Our Ref: FG/150/19/HH

**Town & Country Planning Act 1990 (as amended)
Town & Country Planning (Development Management Procedure) (England) Order 2015
Application for Planning Permission for Works or Extension to a Dwelling**

Development Single storey side/rear extension

Location 3 Downview Road Ferring

project:	4 DOWNVIEW ROAD, FERRING BN12 6QR		
client:	MR & MRS DEVITT-SPOONER	job ref:	SI233
title:	PLANNING APPLICATION	scale 1:50 & 1:100 @A1	
date	December 2019	dwg no: PL01	rev: A

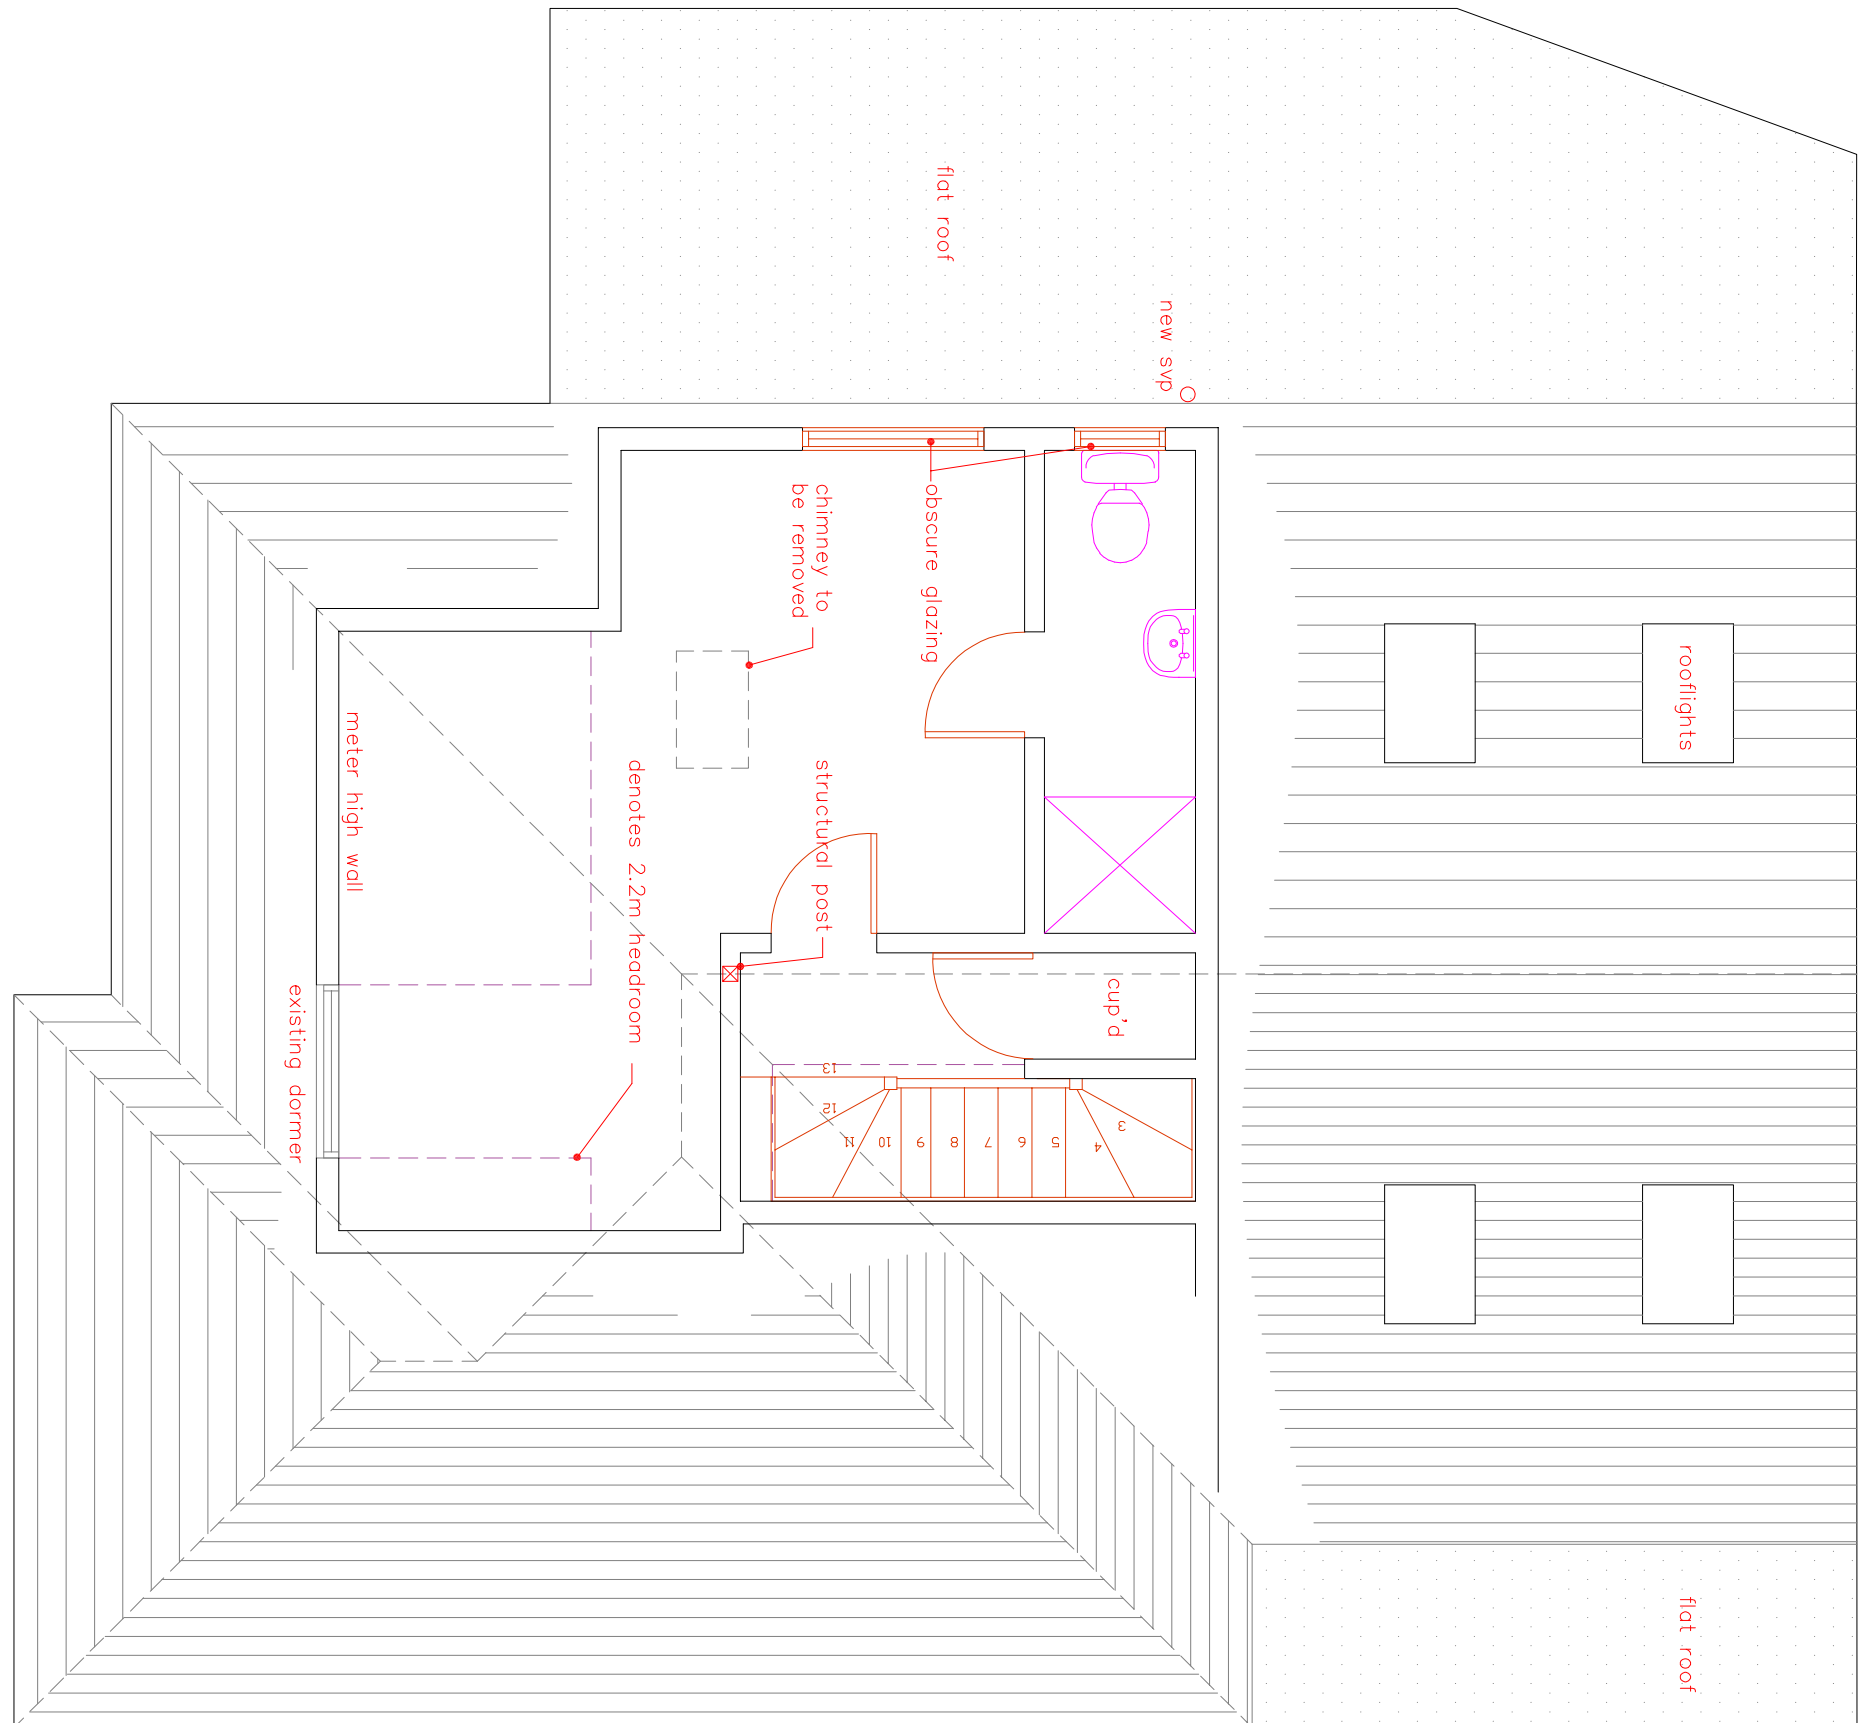
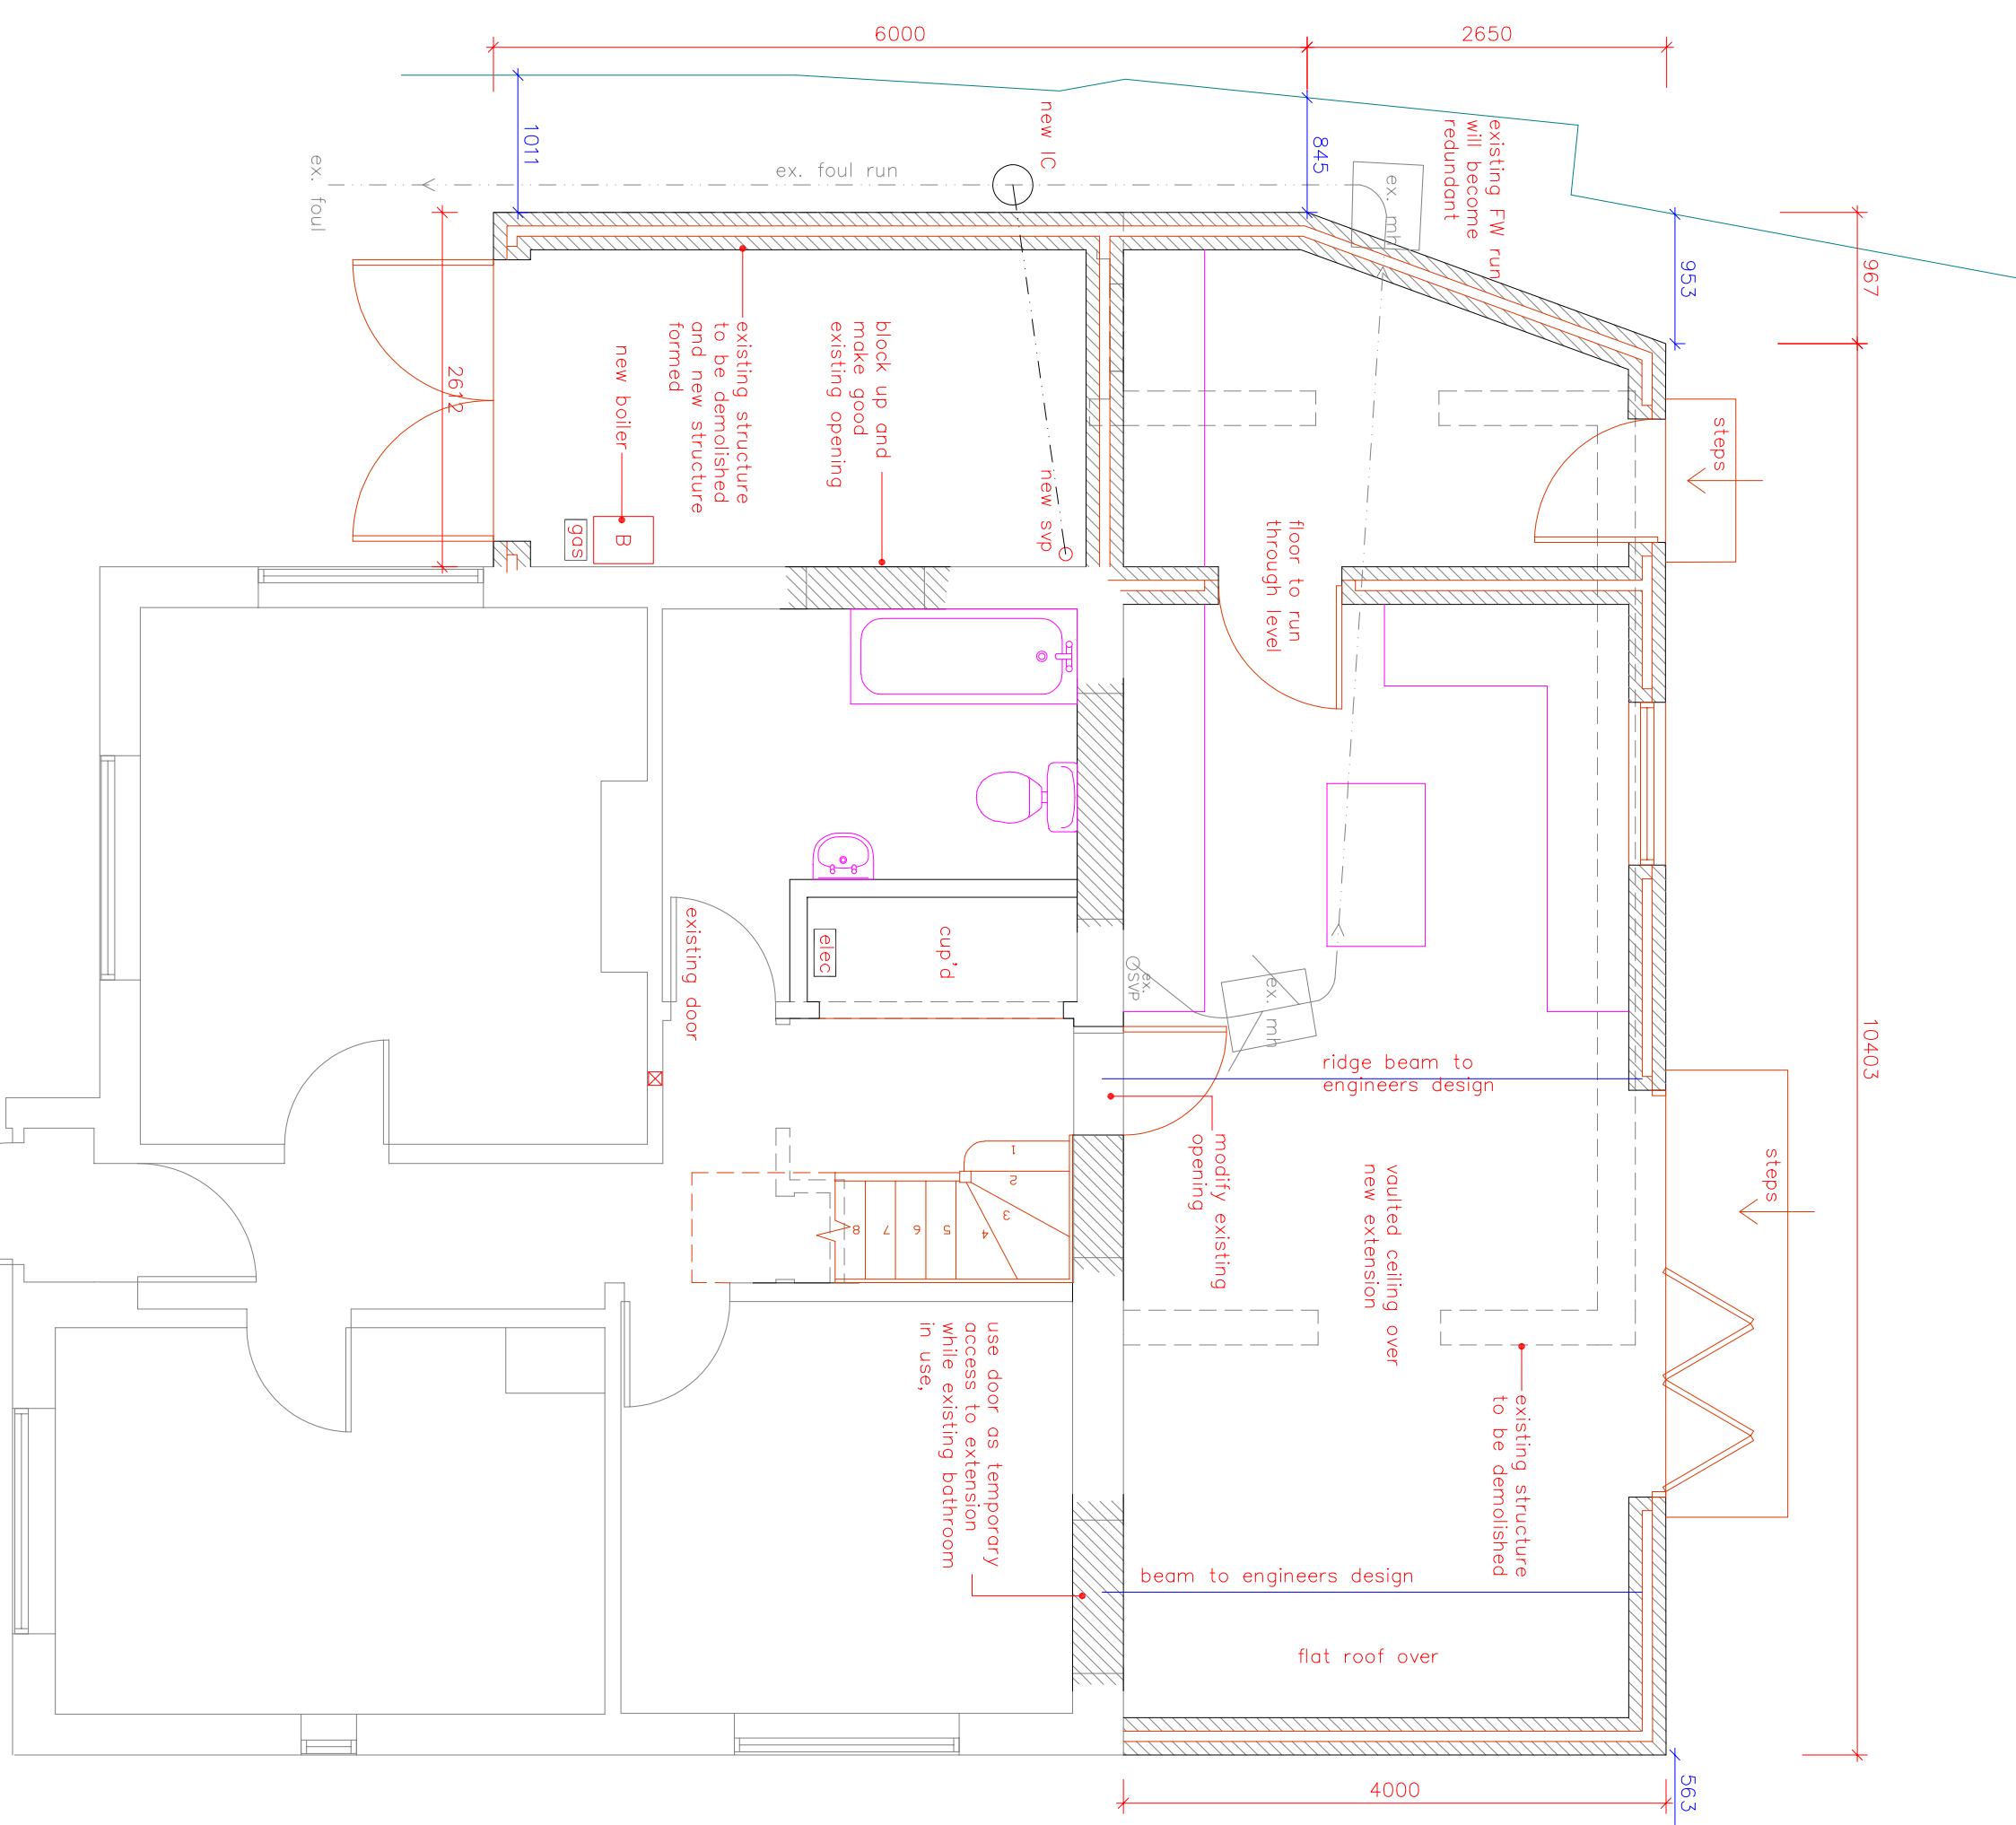
Block Plan: You are required to have dimensions on the block plan from the proposed extensions to all site boundaries.
